**Reference: 1795 Montreal Road  
Site Plan Control Application  
Response to Comments  
Our File No.: 116151**

The following letter has been prepared in response to comments received from Evode Rwagasore dated November 22<sup>nd</sup>, 2018 on the Site Plan Control application for 1795 Montreal Road. This letter addresses all comments received on the Site Plan Control Application Resubmission package provided to the City of Ottawa on October 29<sup>th</sup>, 2018.

REV # 5

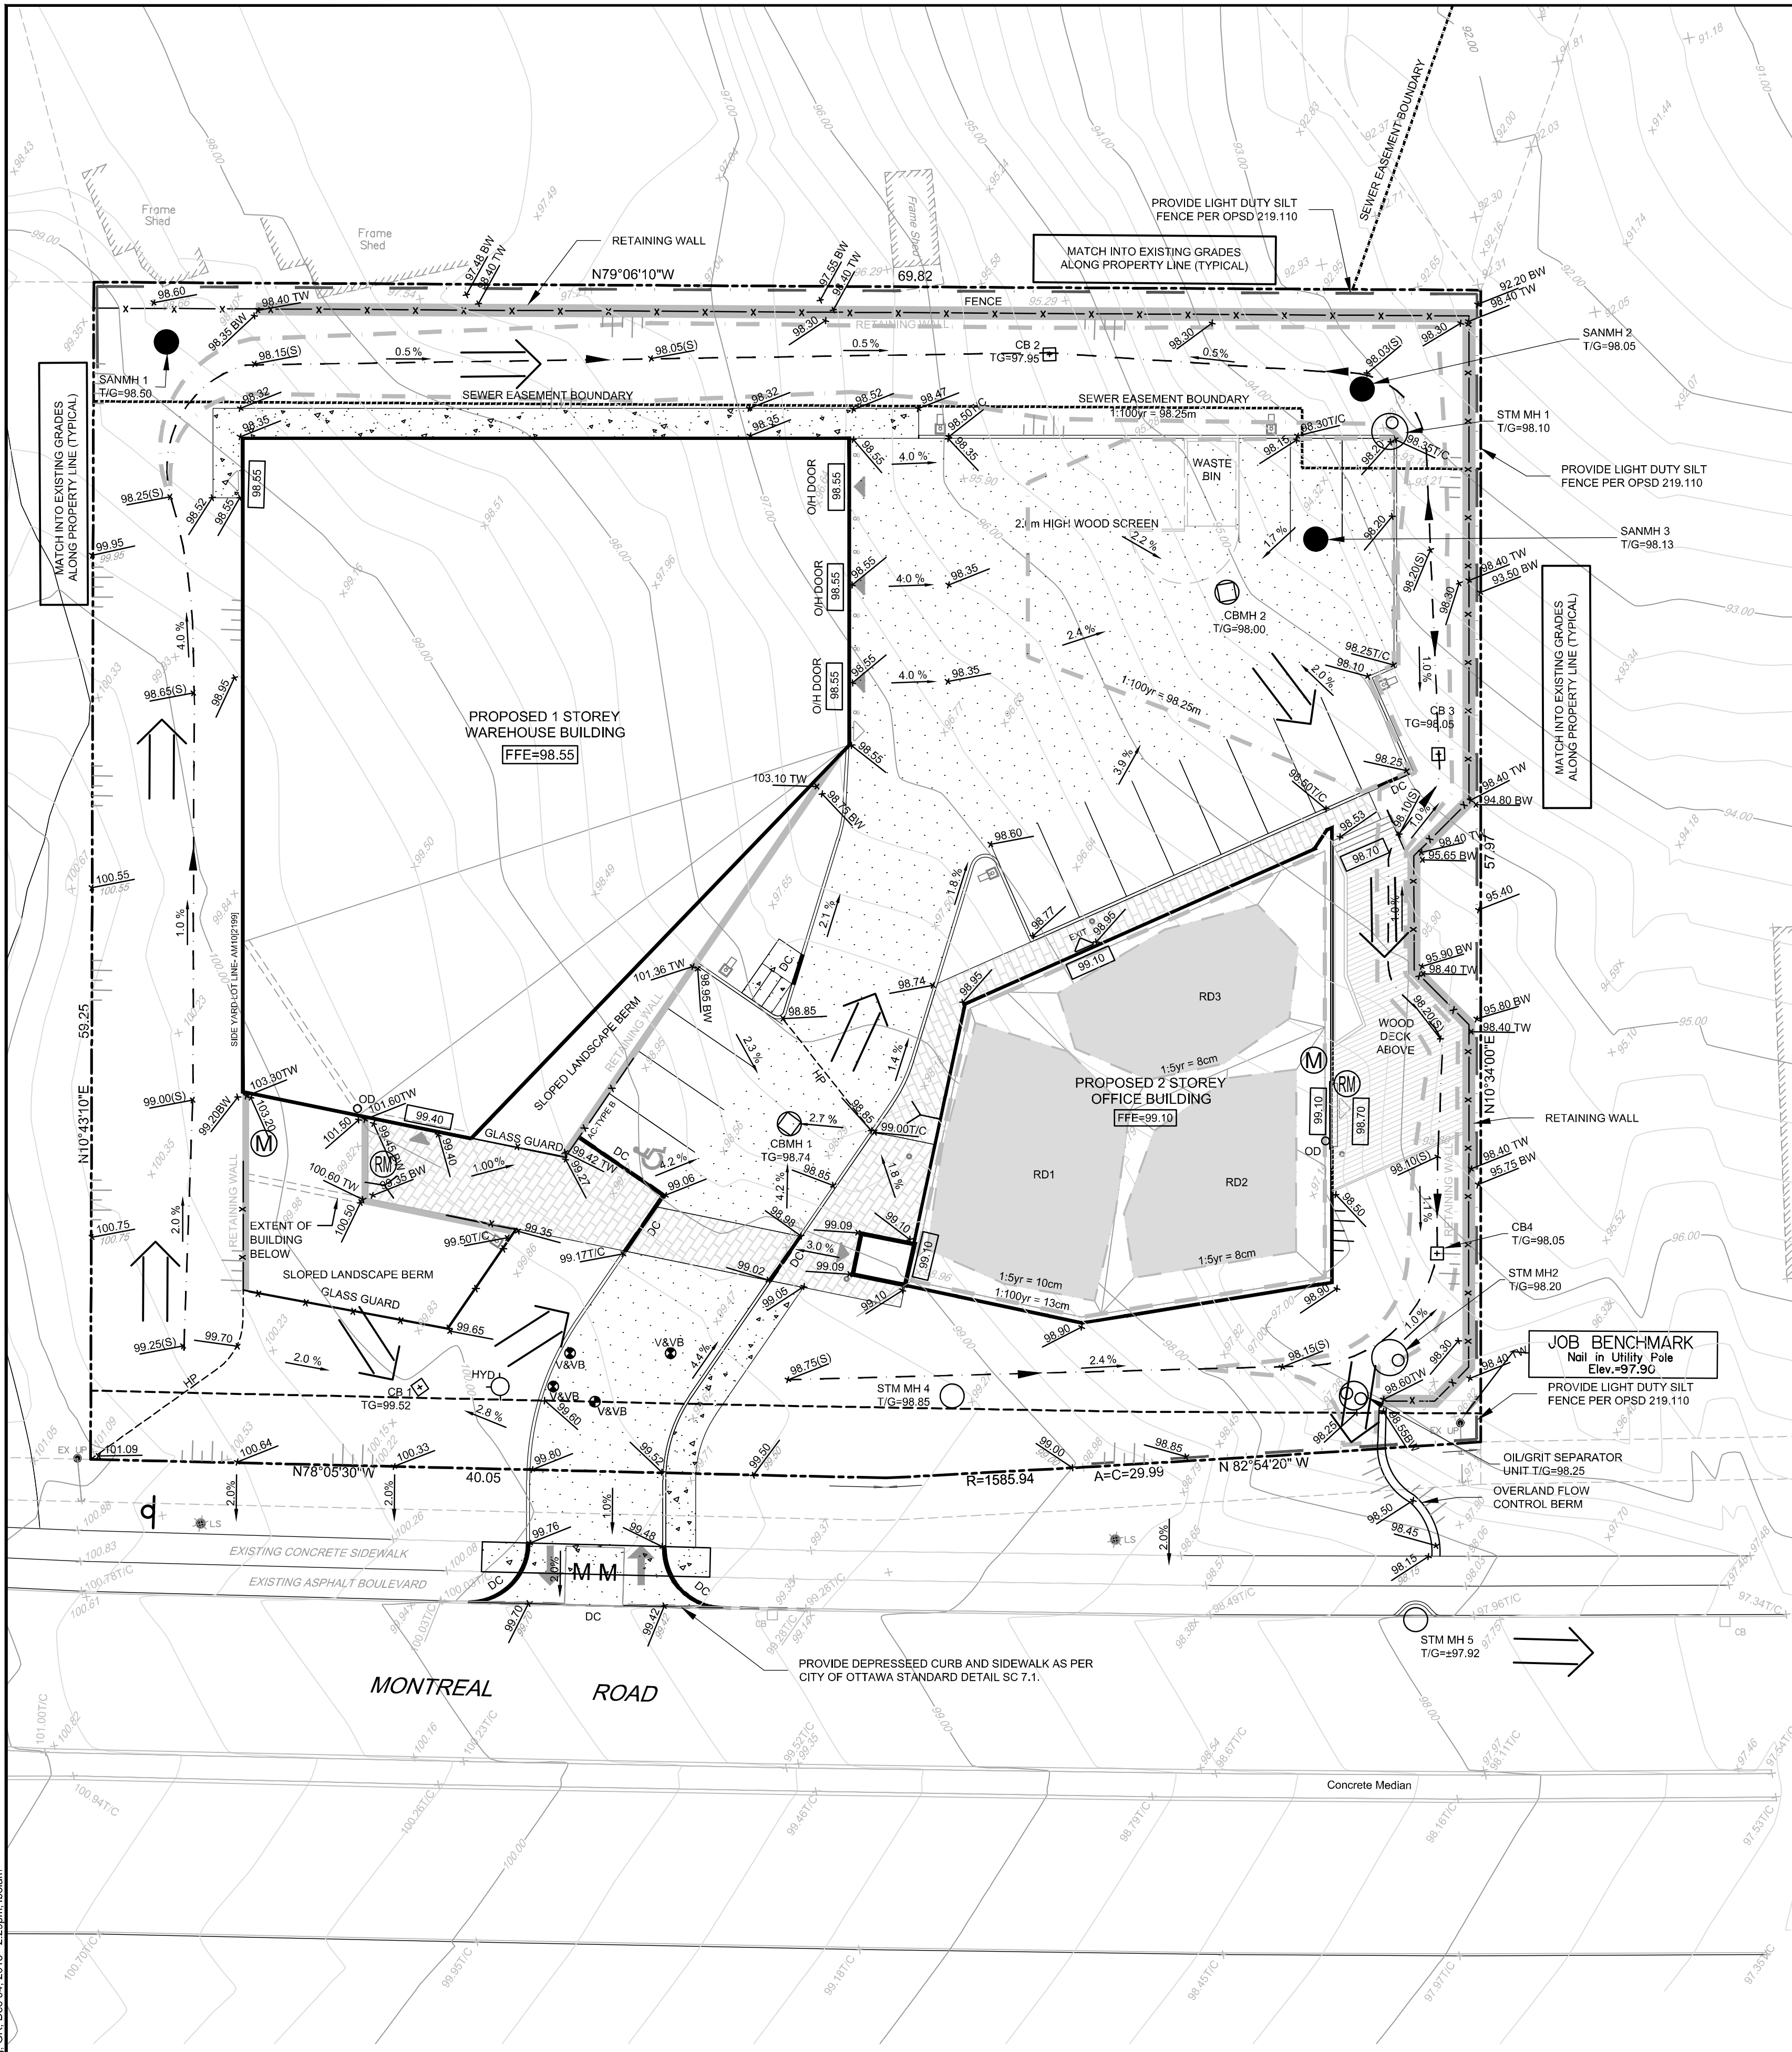
A1. *"The Survey plan shows the existing from the center line of the roadway to the existing property line to be 15,27 metres. Although you have provided the widening but you have not illustrated it."*

*You need to show on the Site Plan from the center line of the roadway a dimension to the new property line. The Dimension should be 18.75 meters."*

All plans have been revised to show the required road widening of 18.75 metres from the centreline of Montreal Road.
